Re: Edmondson Park Mixed-Use Development – SSD-88953706 – 4-8 Buchan Avenue, Edmondson Park

Attachment 1 – SSD-88953706 – 4-8 Buchan Avenue, Edmondson Park – Consolidated Council Feedback

Site 5 General Floor Plan - Ground

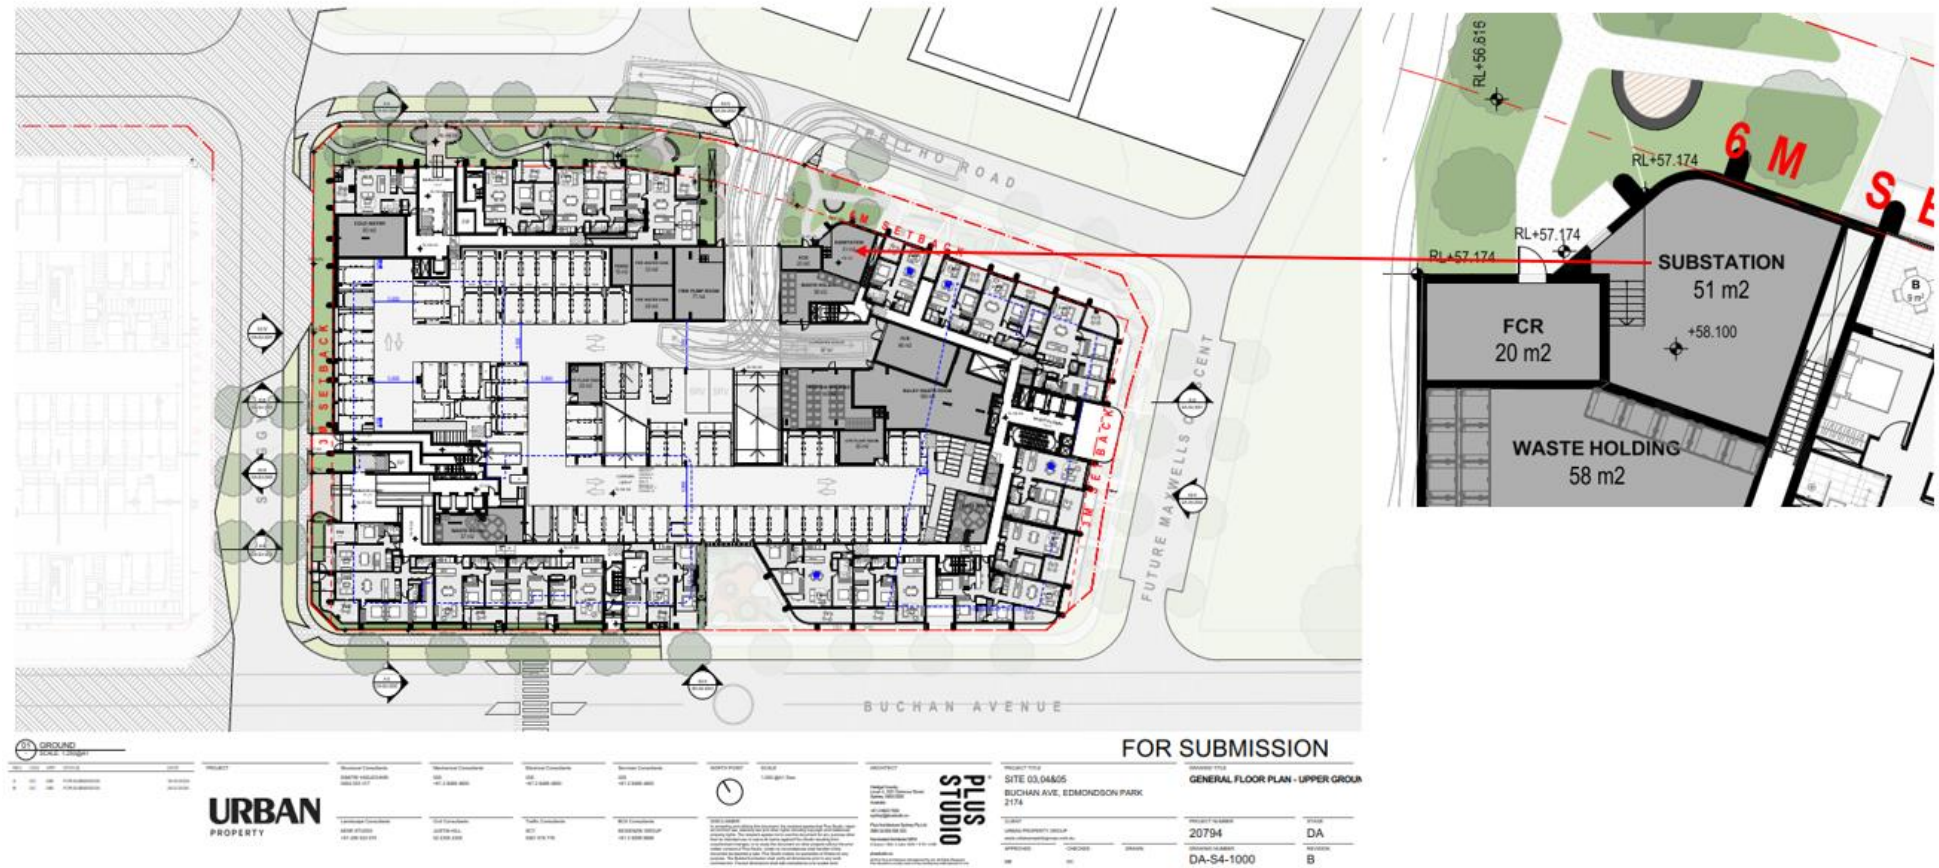
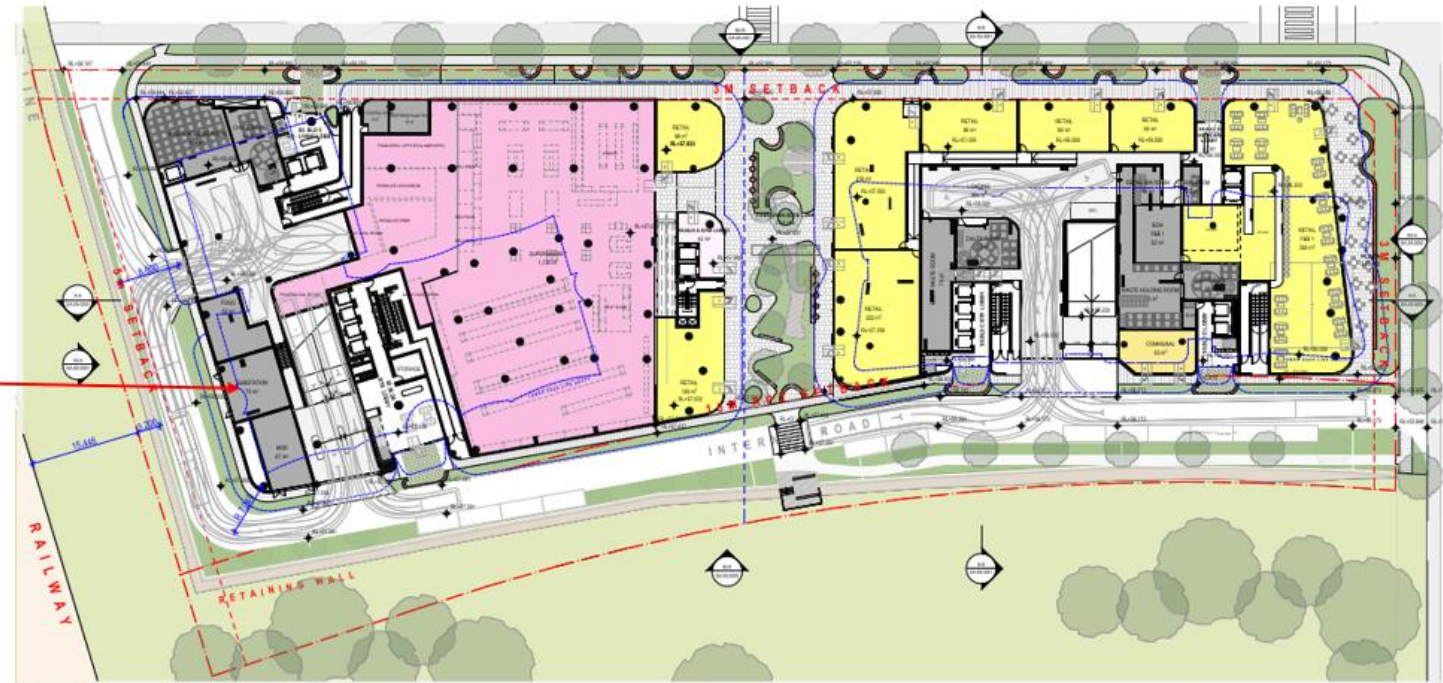
- d) Passive surveillance and activation of the public domain is very poor at the southern elevation of Site 5. The frontage is dominated by inactive facades with the loading dock access, the waste rooms and substation at Ground Level, plant rooms at Level 1, and the communal co-living area in Level 2.

Emergency egress from the proposed childcare facility on Site 5 is fully reliant on the emergency stairs within the residential lift lobbies. This raises concerns with the operation of the facility and management of children exiting the centre in the case of an emergency.

Considering the scale of the Proposal, alternative locations of the childcare facility should be considered which are directly accessible from the Ground Floor and preclude the need for use of emergency stairs by large groups of pre-school aged children.
